Planning & Urban Development Department

RE: 56 & 60 Bradley Street – 188-A-027 & 028 – R-3 Residential Zone

**Plan Depicting The Results Of A Boundary Survey  
& Proposed Lot Division Made For**  
**Scott A. Harding**  
Northwesterly Sideline Of Bradley Street  
Portland, Maine

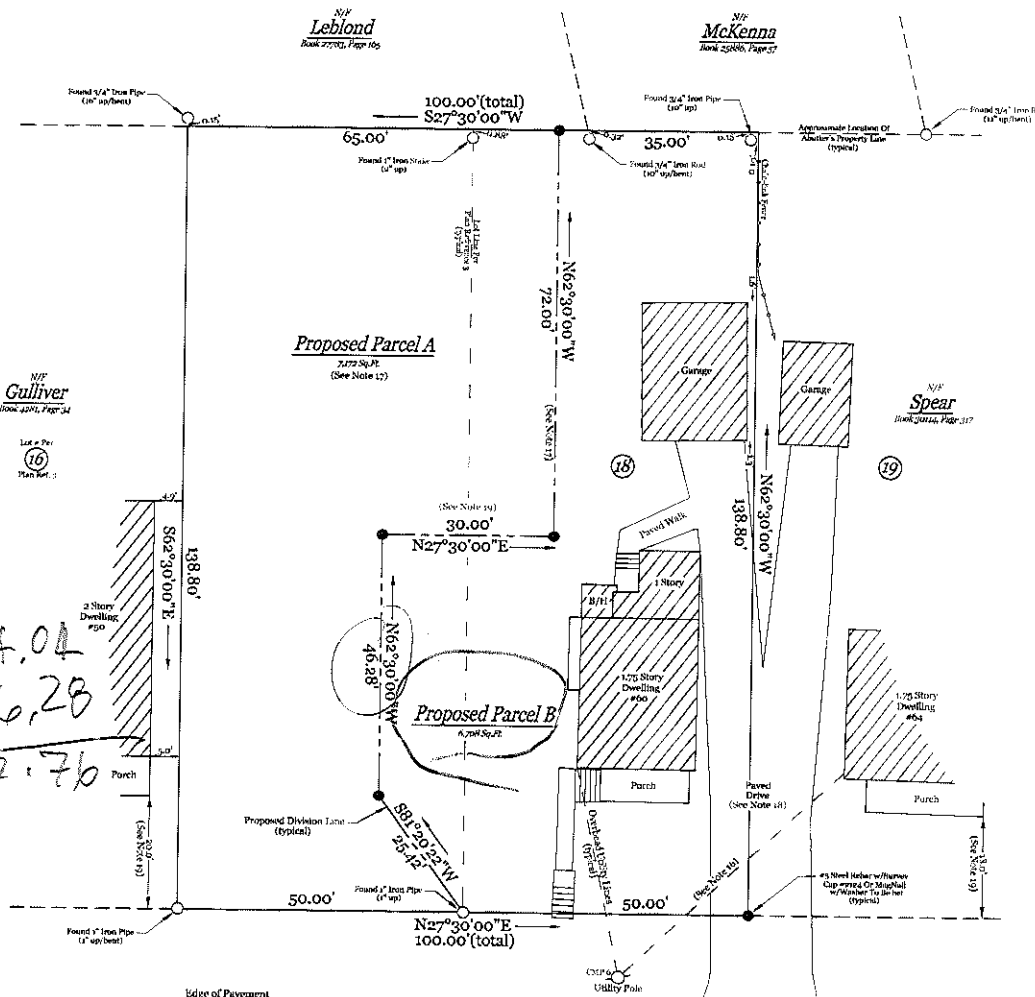
Proposed Parcel B, with the existing single family, is meeting all the underlying R-3 zone requirements, including but not inclusive, the minimum lot size, street frontage, lot width, setbacks and parking. Proposed Parcel A is also meeting the underlying R-3 zone requirements, such as the minimum lot size, street frontage and lot width. Although the Land Use Zoning Ordinance does not require "building envelopes" to be shown on submitted surveys, they do show availability as to where a structure can be placed on a lot. The envelope on Proposed Parcel A is misleading. In the first 75' from the front property line, the given envelope implies that a structure could be placed in that area. It cannot. I also want to point out that because the lot is widened after 75' from the front property line, there are implications that the 30 foot line labeled "N27°36'48"E becomes a front setback line. A principal structure placed in front of that line is required to meet the minimum front setback. The R-3 zone normally requires a 25' front setback. However, section 14-90(d)1 allows the minimum front yard to be reduced if the properties on either side are less than 25'. Their front setbacks can be averaged and used for the newly created vacant lot. The envelope along the N27°36'48"E should be revised to show the proper front yard setback for this lot.
